Lime Down

Solar Park

Statement of Common Ground with Natural England (Tracked)

Document Reference: EXAM/8.4

Viewpoint 6 - Unnamed Lane - Existing Winter View
Figure 8-14-6
EN010168/APP/6.2
APFP Regulation 5(2)(a)

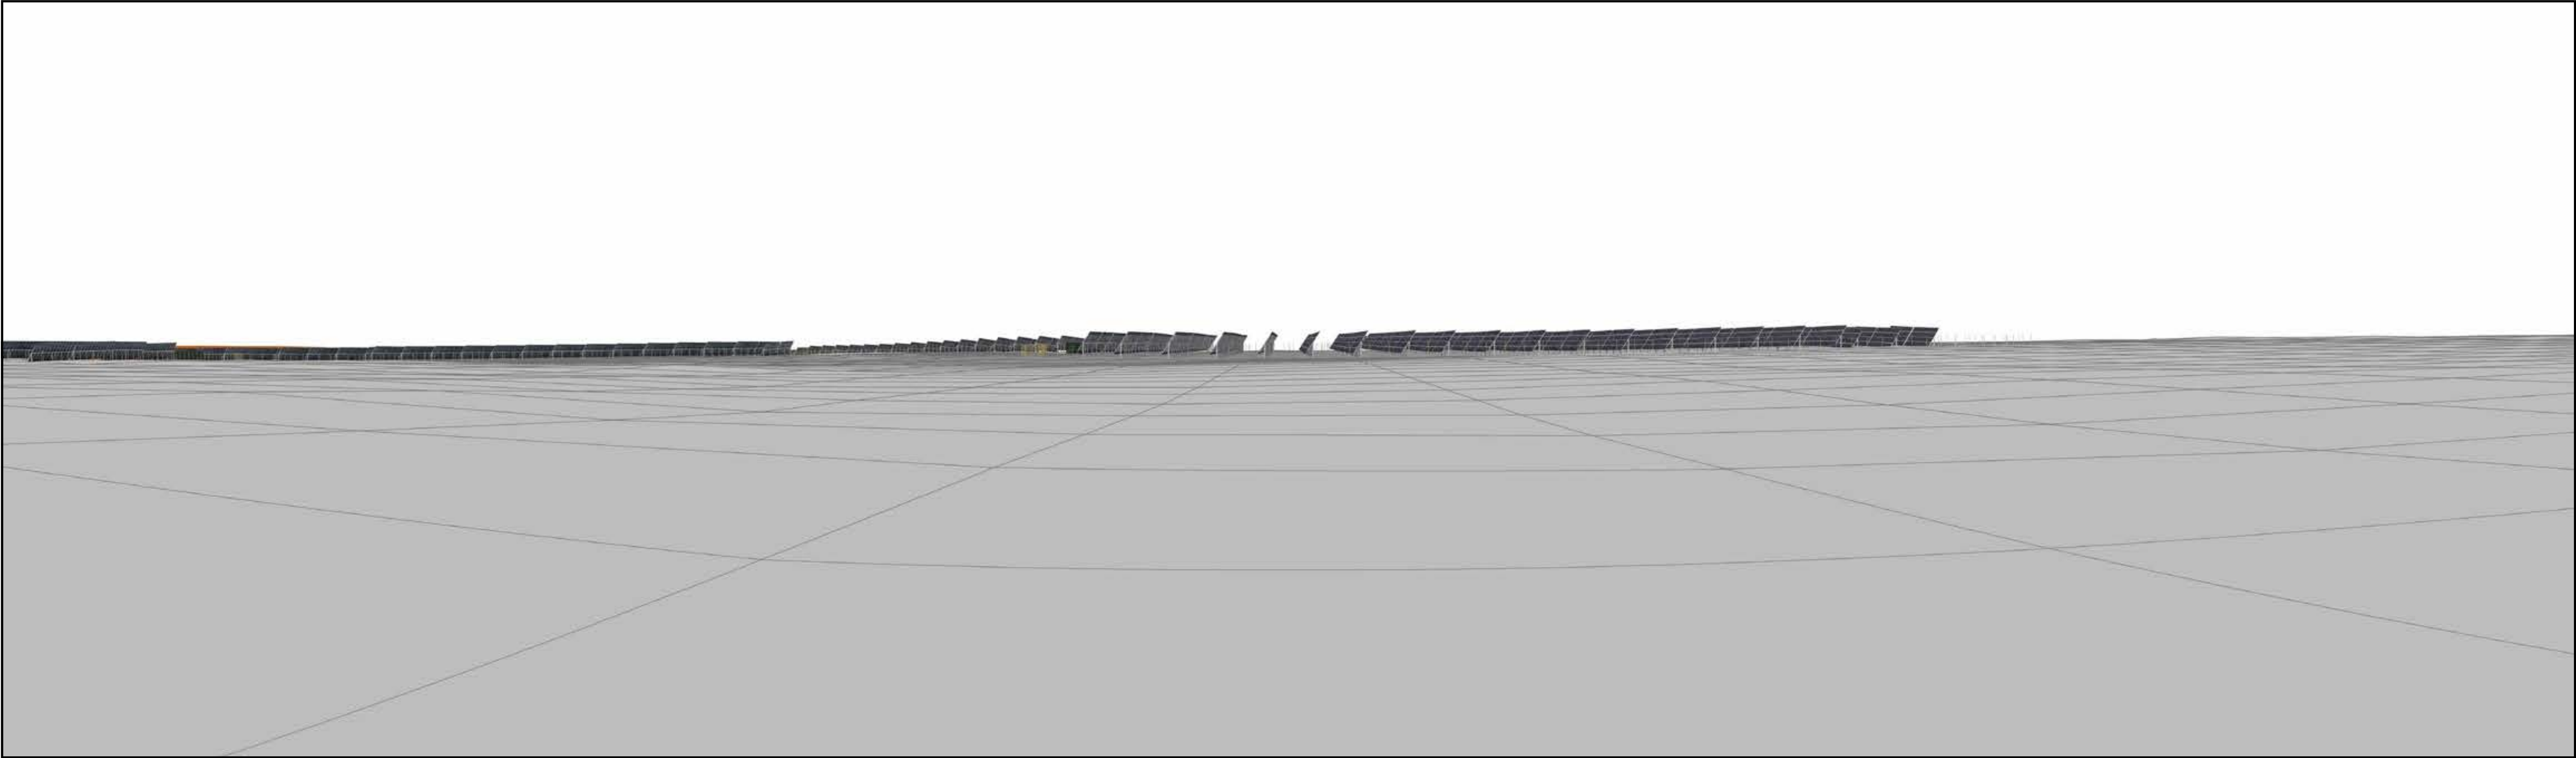
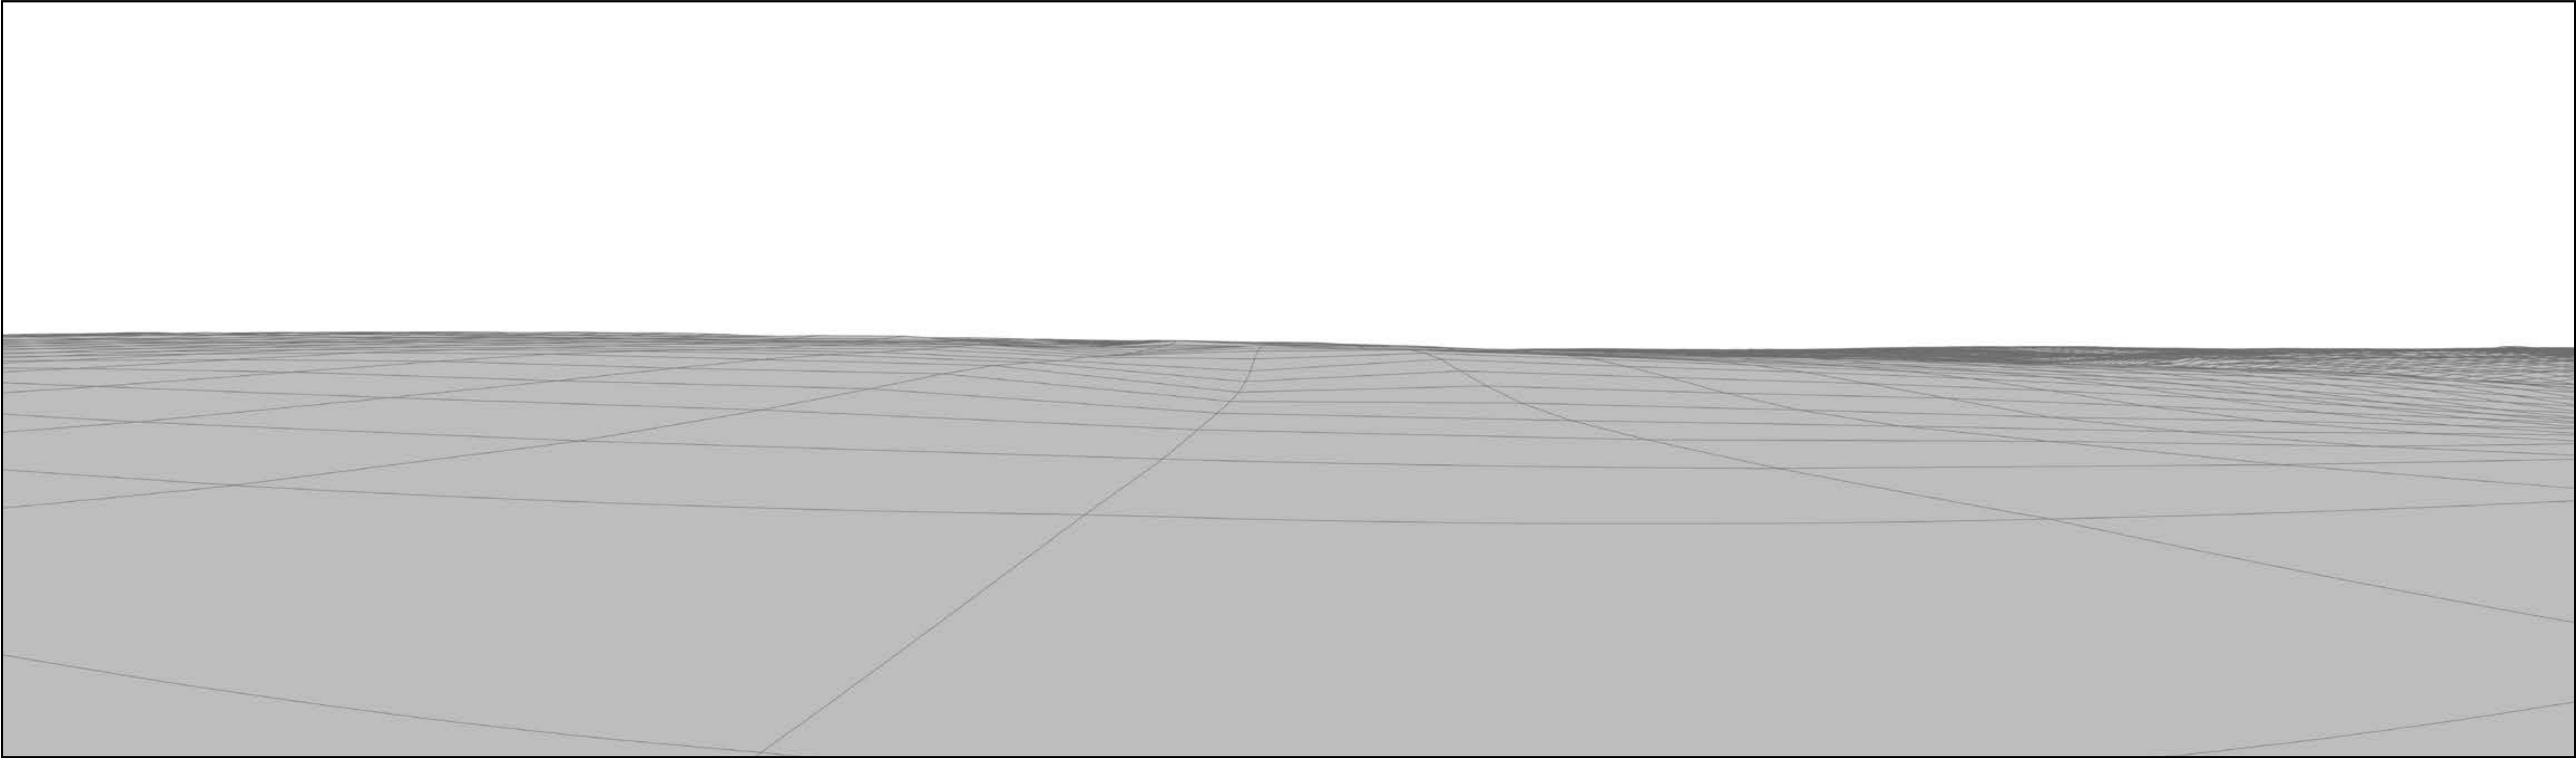
3.2.5	Embedded Design Mitigation	Viewpoints 4 & 6 are located on the boundary of the National Landscape adjacent to the Order Limits. Baseline photography demonstrates that the Order Limits are more visible from National Landscape in these locations due to the proximity between the National Landscape and the Order Limits. However, as shown in the Works Plan, panels will not be located within the northern extent of field A1 or within the entirety of fields A11 and A12. This is welcomed and will reduce	The approach and proposals for embedded mitigation set out within Section 8.9 of ES Volume 1, Chapter 8: Landscape and Visual [REP3-026] , considers the landscape and visual matters associated with the Scheme as part of an iterative process, and is considered acceptable. Establishing planting will add a positive element to this landscape. Vegetation removal, as shown on the ES Volume 2, Figure 3-4 Landscape and Ecology Mitigation	Agreed

Reference	Sub-topic	NE Position	Applicants Position	Status
		the landscape and visual impacts of the proposed development.	and Enhancement Plans [REP3-037] is relatively minimal.
